**Consultation Response from Alan Smith,  
KC Waste Strategy (Refuse & Recycling)**

**2025/91731 Land off, Bankfield Drive, Holmbridge, Holmfirth, HD9 2PH**

**Discharge of details reserved by conditions 12 (pedestrian connection), 13 (cycle parking), 15 (collection of wastes), 21 (Remediation Strategy), 23 (external materials), 24 (windows and doors), 25 (electricity substations), 26 (boundary treatments), 27 (external lighting) on previous permission 2023/91212 for erection of 21 dwellings with access from Laithe Avenue**

**Date Responded: 07/07/2025**

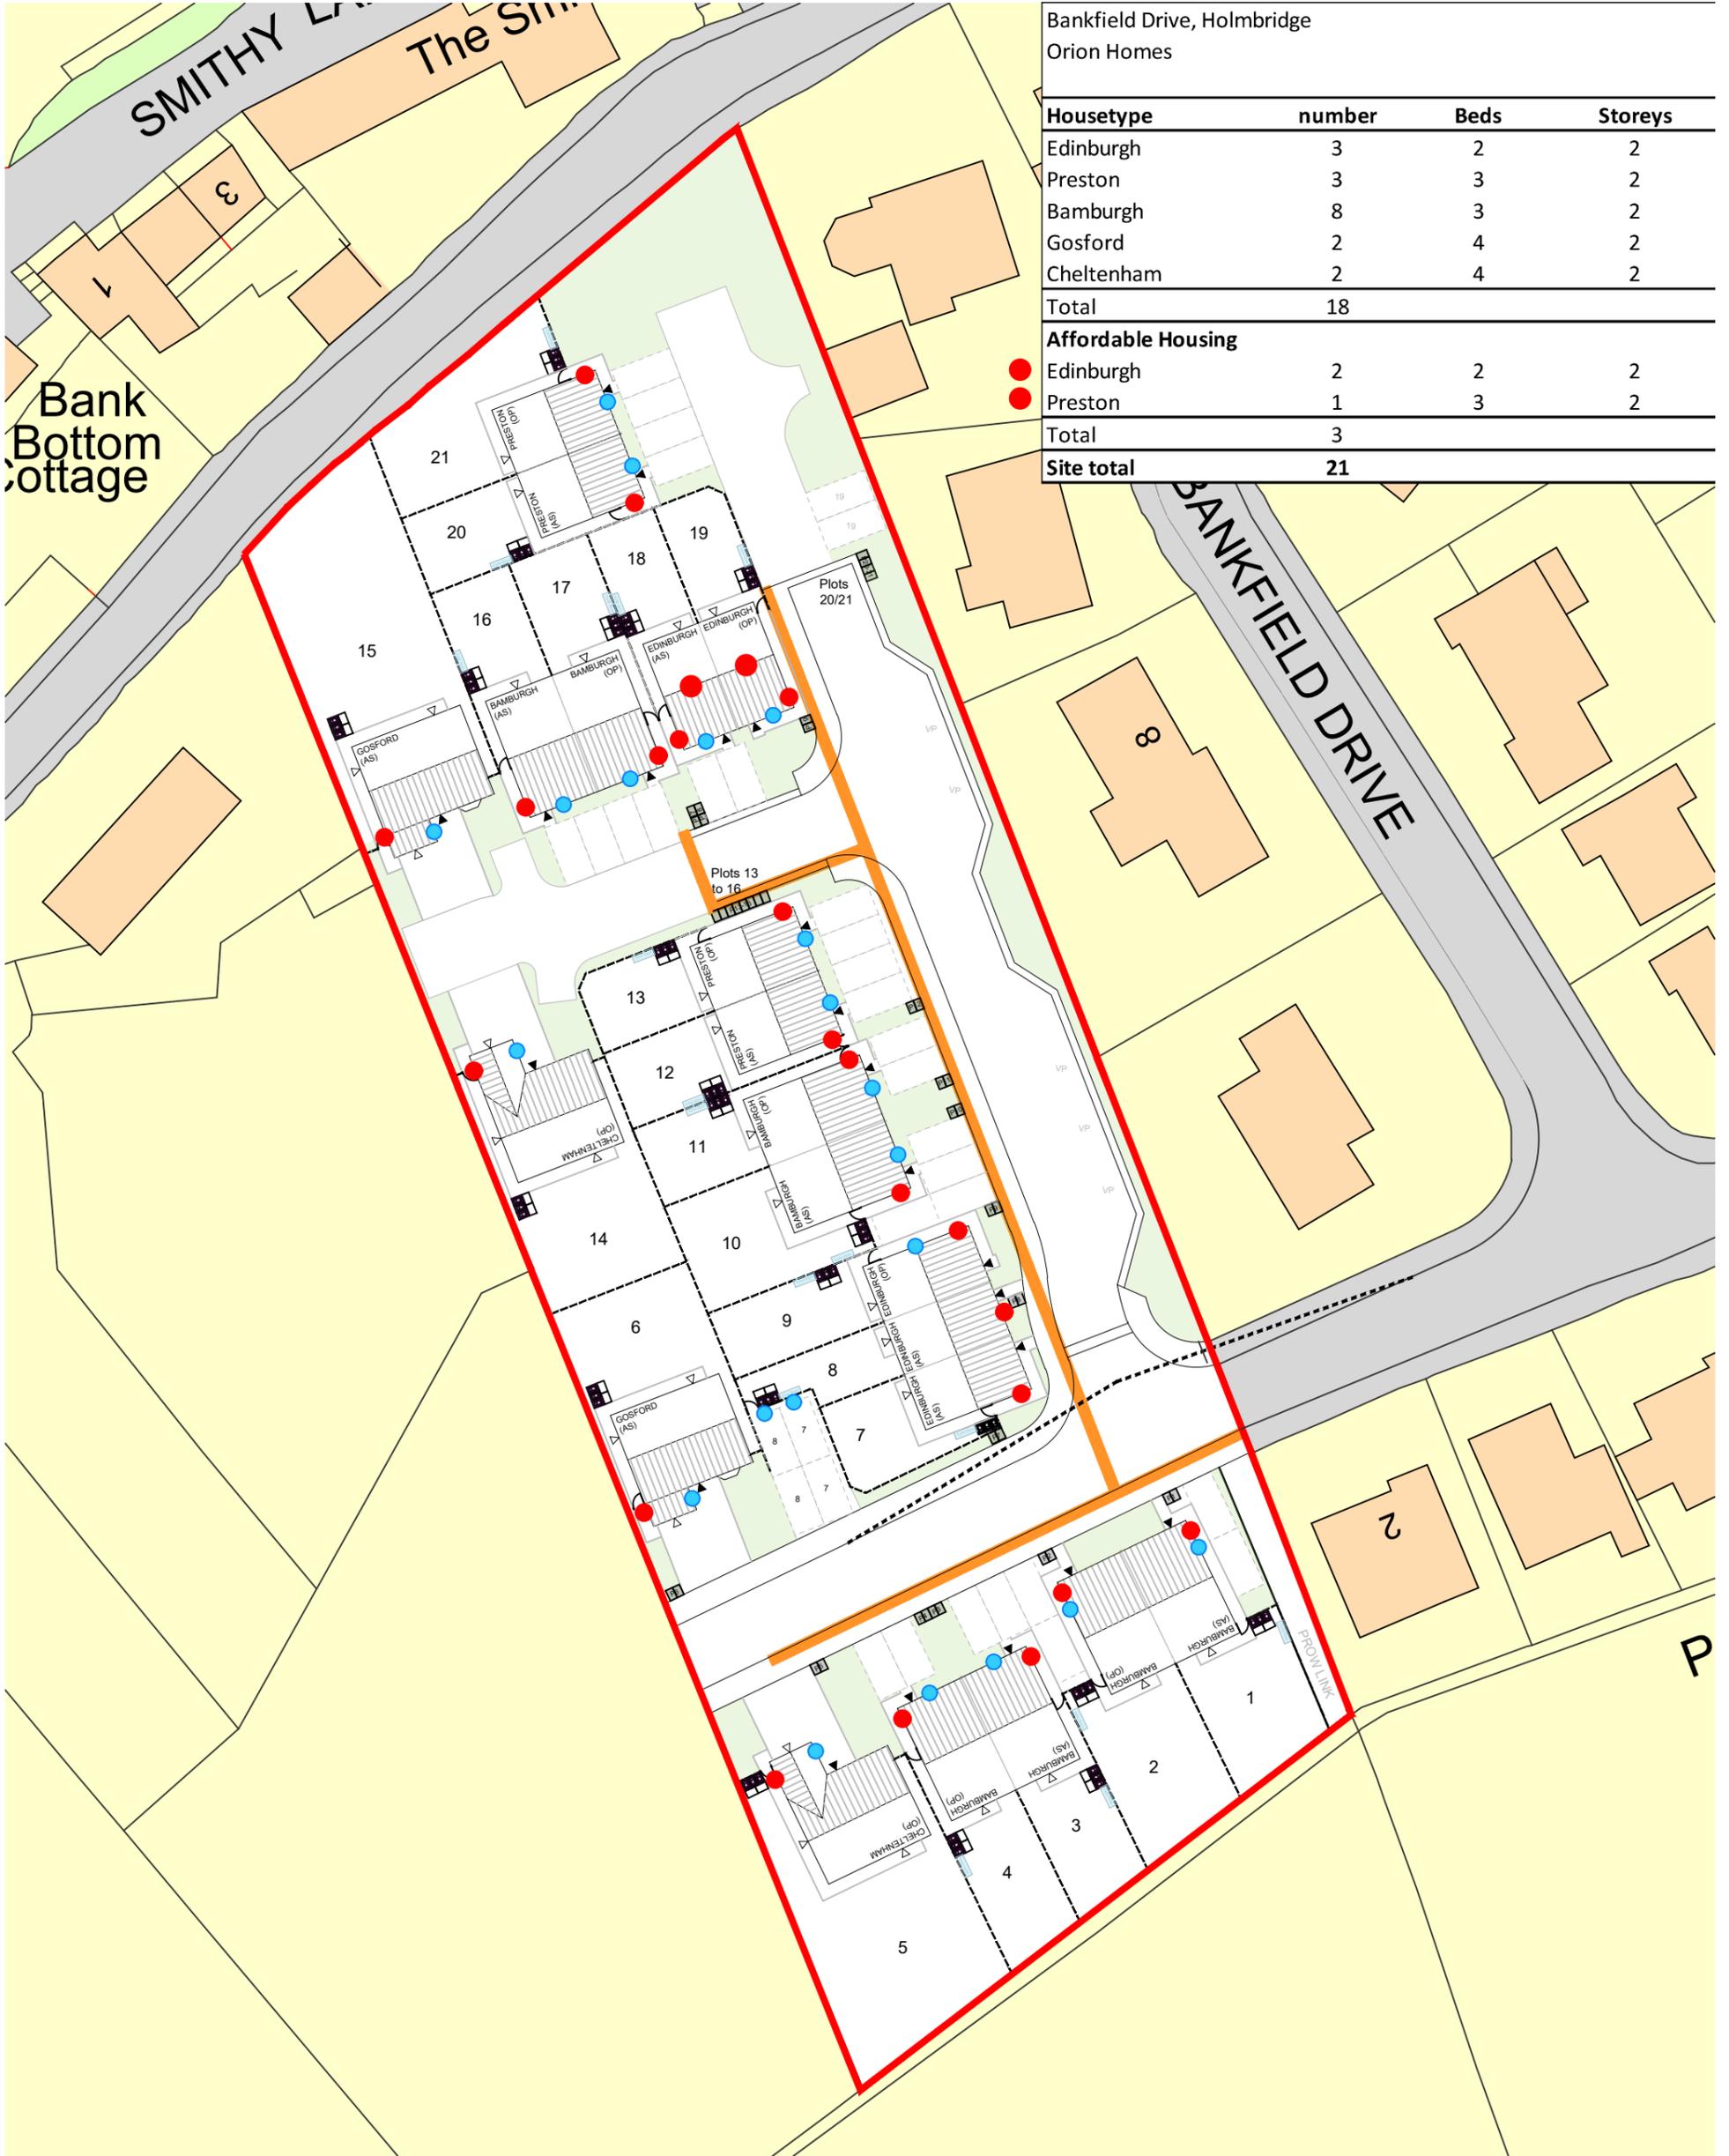
The applicant has submitted the drawing General [id 1093396] Size: 767KB 25/06/2025 - Site Layout 003 X. This shows the location of proposed bin storage points and bin collection points throughout the development, as shown in the image below.

I can confirm that the proposed bin collection points and bin storage locations on the site are acceptable to the WCA.

**Before full discharge of this condition the WCA would like clarification as to whether the site will be phased or whether it will only be occupied once it is built. If it is a phased development the Condition 15 will still apply in terms of temporary waste collection arrangements.**
